Engineers comments for EG/59/12/

APPLICATION EG/59/12/

Site Address: 17 Elm Grove South Barnham PO22 0EJ

Grid Reference: 495505 104712
Description of Works: Laying of permeable hardstanding, A/C unit/enclosure, handrail and external lighting

TITLE SITE PLAN

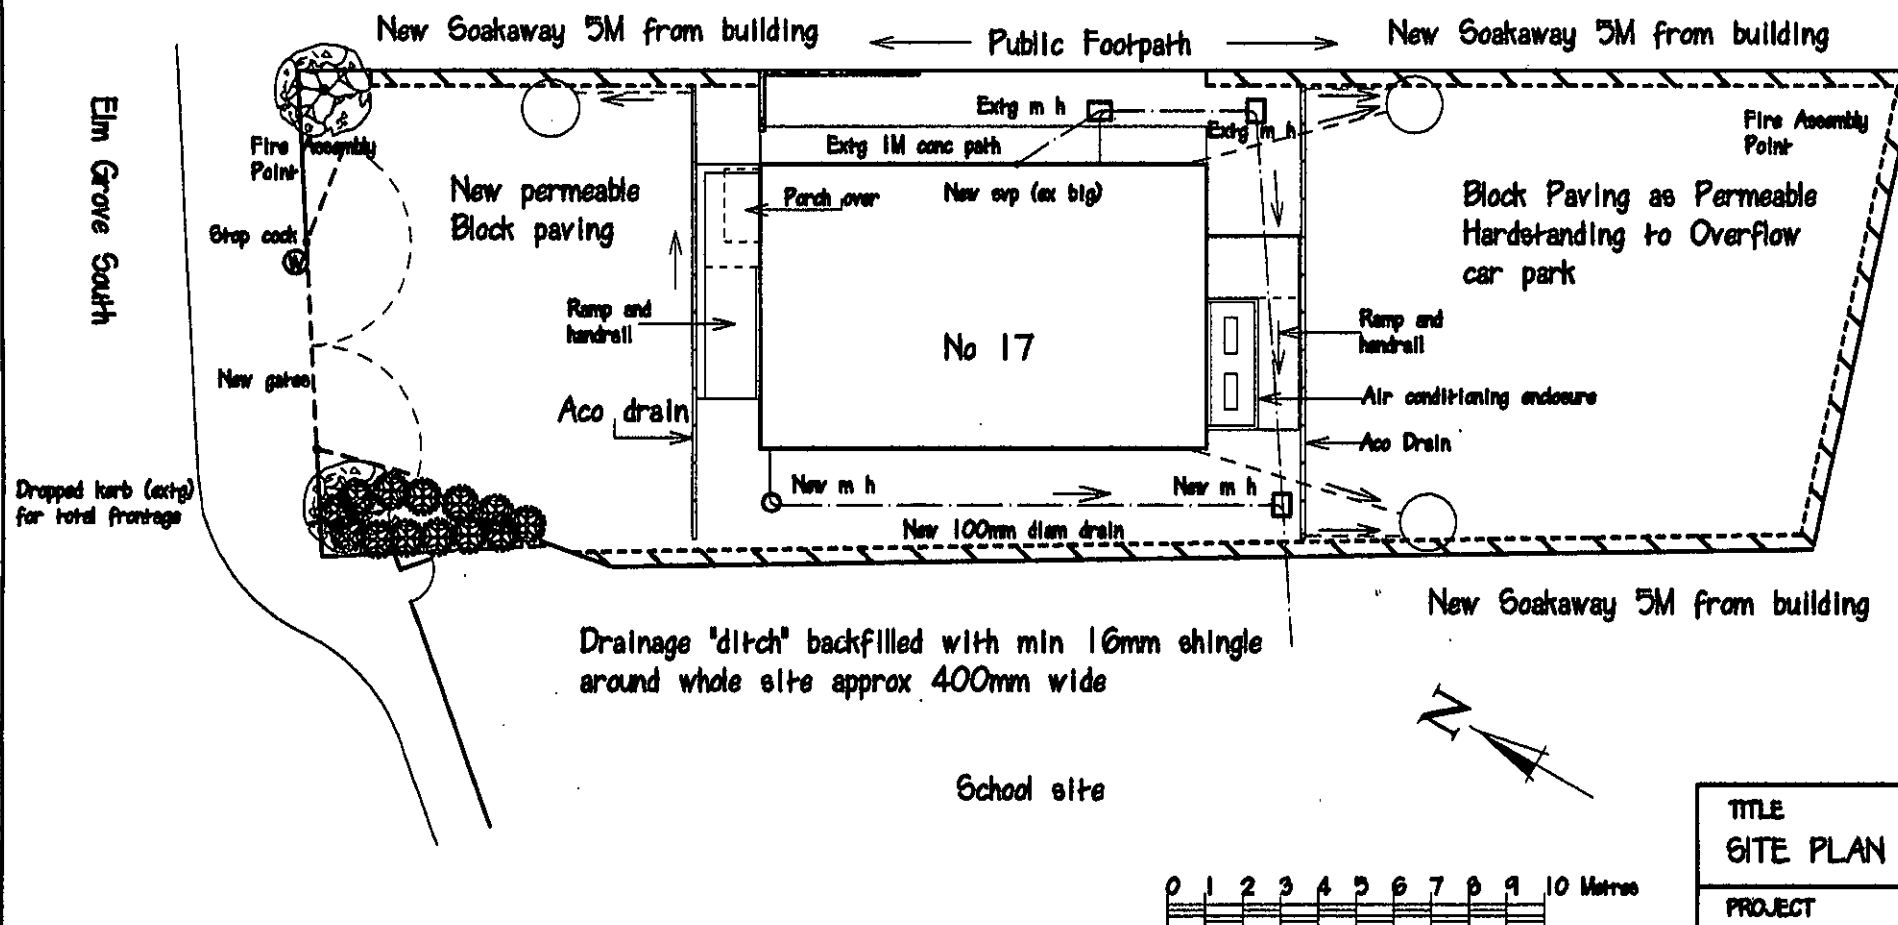
The permeable parking areas if constructed and designed to the required standard will not increase flood risk to any property. The permeable parking area designs will need to be submitted and supported by percolation testing.

Development shall not commence until full details of the proposed surface water drainage scheme have been submitted to and approved in writing by the Local Planning Authority.
Percolation testing to BRE 365, or similar approved, will be required to support the design of any Infiltration drainage.
